104 Exchange St - permit SIGN2018-00059

Christina Stacey <cstacey@portlandmaine.gov>
To: peter@bissellbrothers.com

Just a quick question on this application - the window signage is proposed to stay the same, correct? I just wanted to make sure there was no intent to cover the windows with any film or sticker to make them not transparent.

proposed

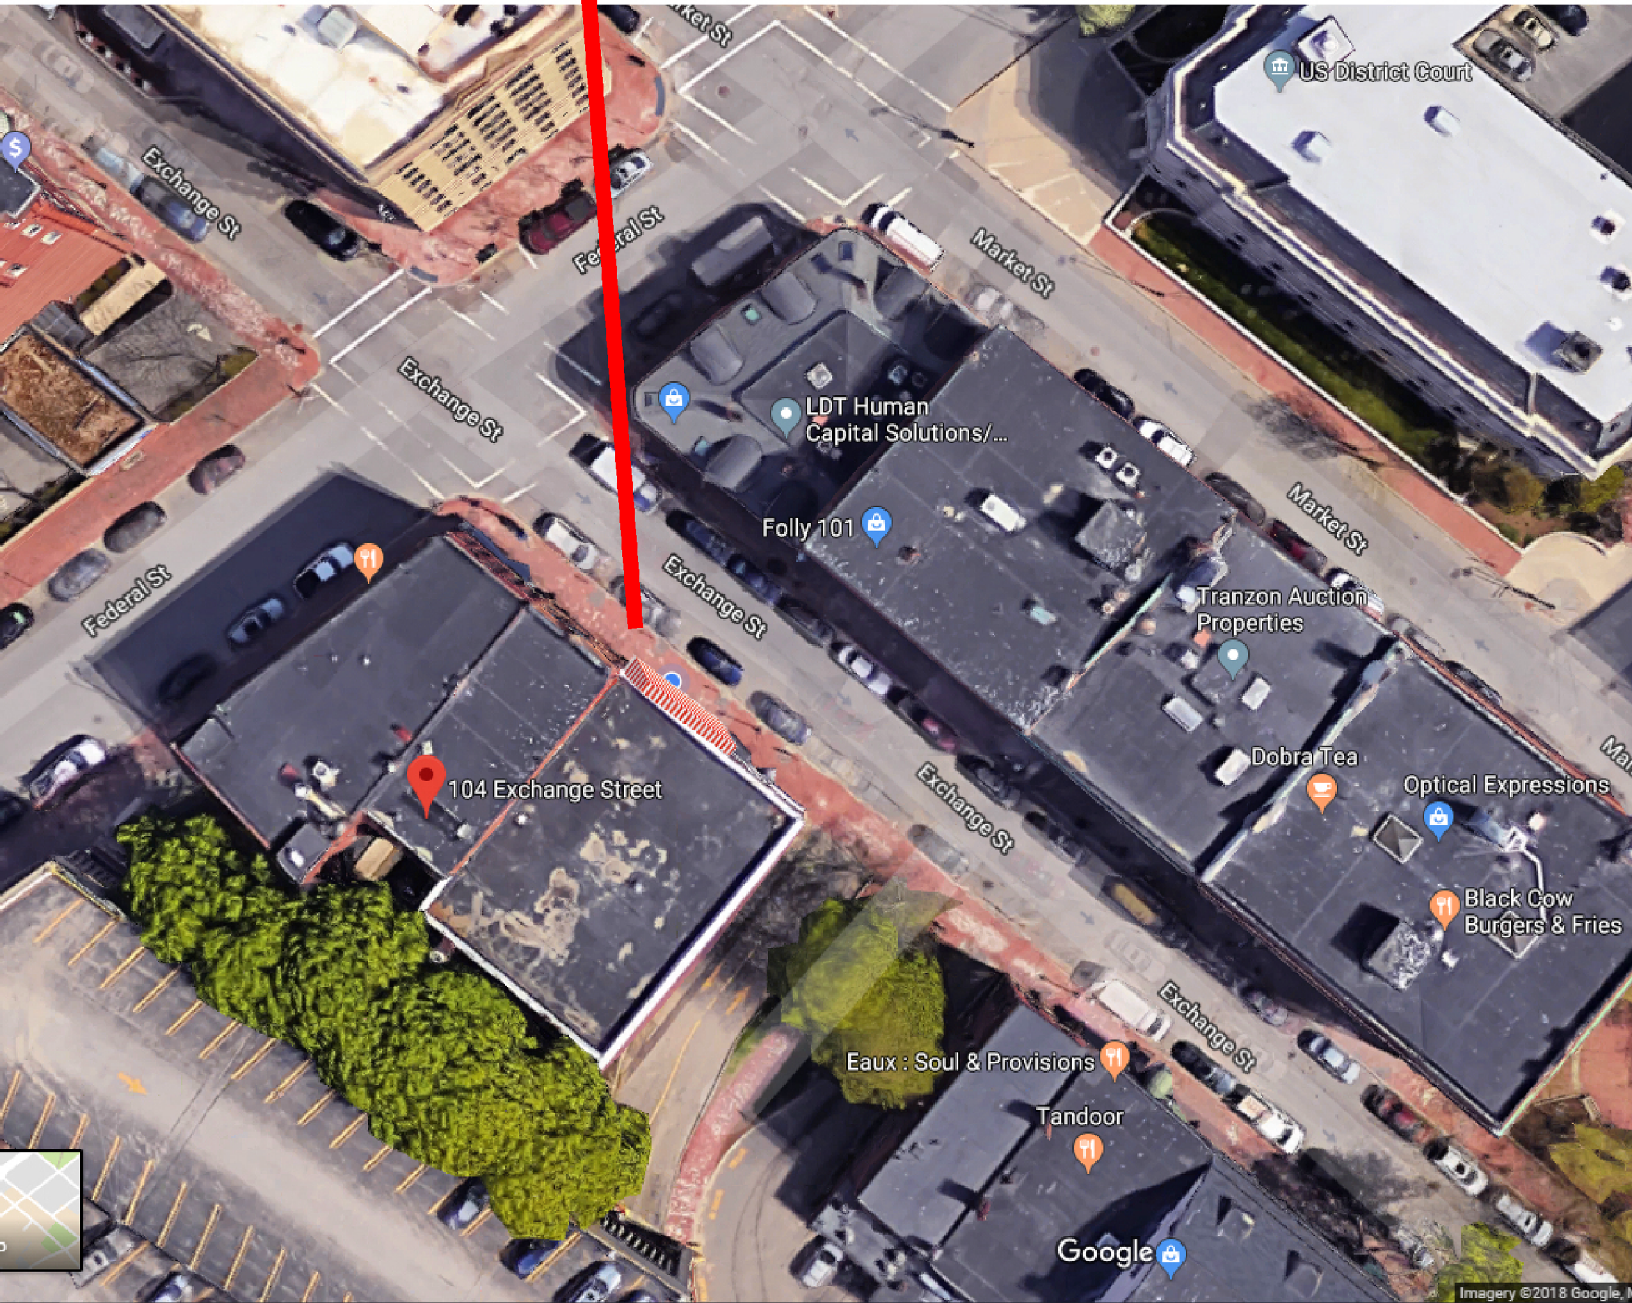
OK thanks. I think the mock-up just had the windows colored in with blue (probably to represent glass) and I just wanted to make sure it wasn't going to be some kind of visual blocking on the windows, as that is not allowed in this zone.

No, the windows are clear with vinyl sticking on them currently. The mock-up photo you may be referring to was taken when we were still in planning and the windows were covered in paper

no nothing like that.
